Ribble Valley Borough Council
Council Offices
Church Walk,
Clitheroe
Lancashire
BB7 2RA

Phone: 0300 123 6780
Email: developeras@lancashire.gov.uk
Your ref: 3/2025/0997
Our ref: 3/2025/0997/HDC/KW
Date: 06 May 2026

Location: Land off Henthorn Road Clitheroe BB7 3BY
Proposal: Outline application for the erection of up to 115 dwellings, including affordable housing, with public open space, landscaping, sustainable urban drainage system (SuDS) and vehicular access. All matters reserved except for means of access.
Grid Ref: 372961 440676

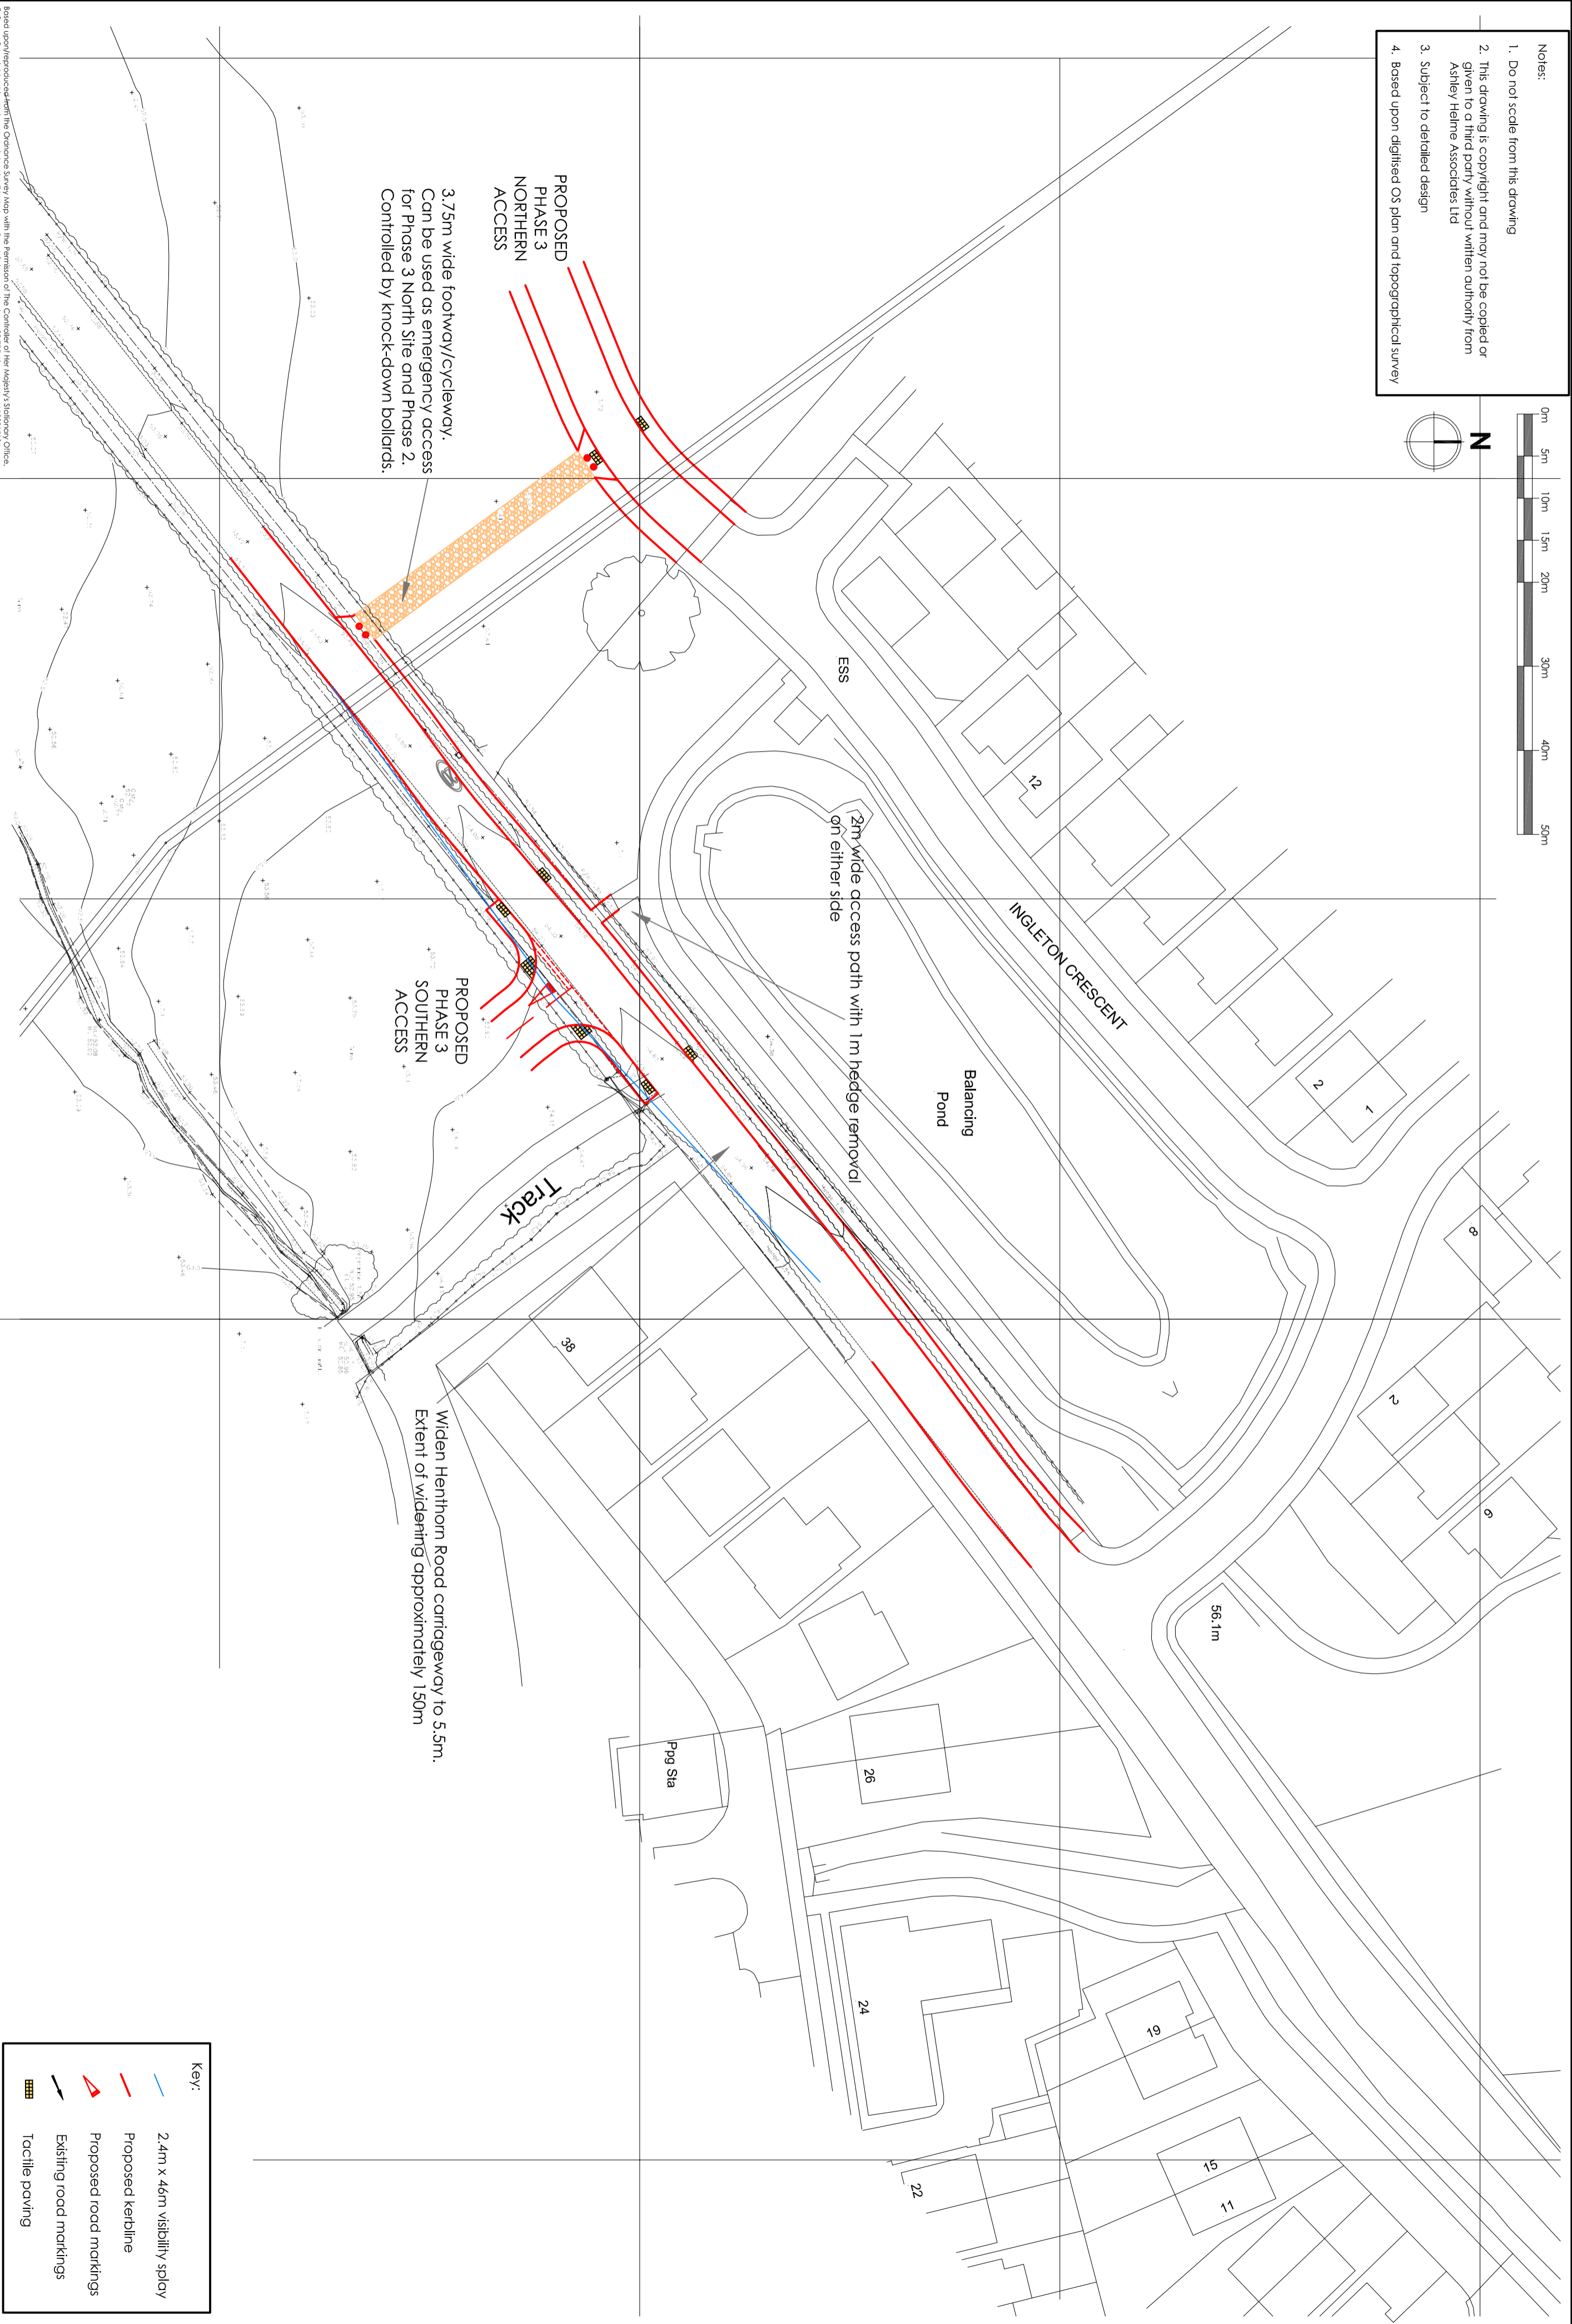
A secondary emergency access arrangement is also provided within drawing number 1677/01, revision G, to provide access to the development which sits to the north of Henthorn Road, as well as serving as an emergency access to the Phase 2 development. The emergency access is 3.75m wide and controlled by knock-down bollards positioned on both sides. The amended drawing shows the access can achieve a visibility splay of 2.4m by 46m (based upon recorded speeds) in both directions.

The LHA previously raised concerns over the lack of pedestrian provisions along Henthorn Road and requested that a 2m footway be extended further along the entire site frontage of the north side of Henthorn Road. The applicant has addressed this and the amendment drawing number 1677/01 Revision G now includes a footway on the north side of Henthorn Road measuring 2m wide. The Technical File Note 4A states that the applicant agrees to provide additional street lighting, extended along the length of the footway from its existing termination. The lighting design and details can be agreed at the detailed design stage and shall be to adoptable standards agreed upon as part of the Section 278 (S278) works with Lancashire County Council.

Drawing number 1677/01, Revision G also includes the access arrangements for the proposed development, which sits to the South of Henthorn Road. The proposed access measures 5.5m for 10m behind the carriageway edge, with 2m footway provision on either side.

As such, the applicant has provided visibility splays at the southern site access with Henthorn Road of 2.4m by 46m in both directions. A slight amendment, to remove a 1m off set, has been made to the visibility splay in which the LHA find acceptable.

The data demonstrates that there is a lack of self-compliance of the speed limit on Henthorn Road and subsequently we would request that mitigation measures are provided to address these concerns. It is understood that the applicant has shown a traffic calming scheme as part of the site access layout. A robust traffic calming scheme including signing and road markings to reinforce the 20mph speed limit shall be undertaken as part of a technical detailed design under a Section 278 agreement.
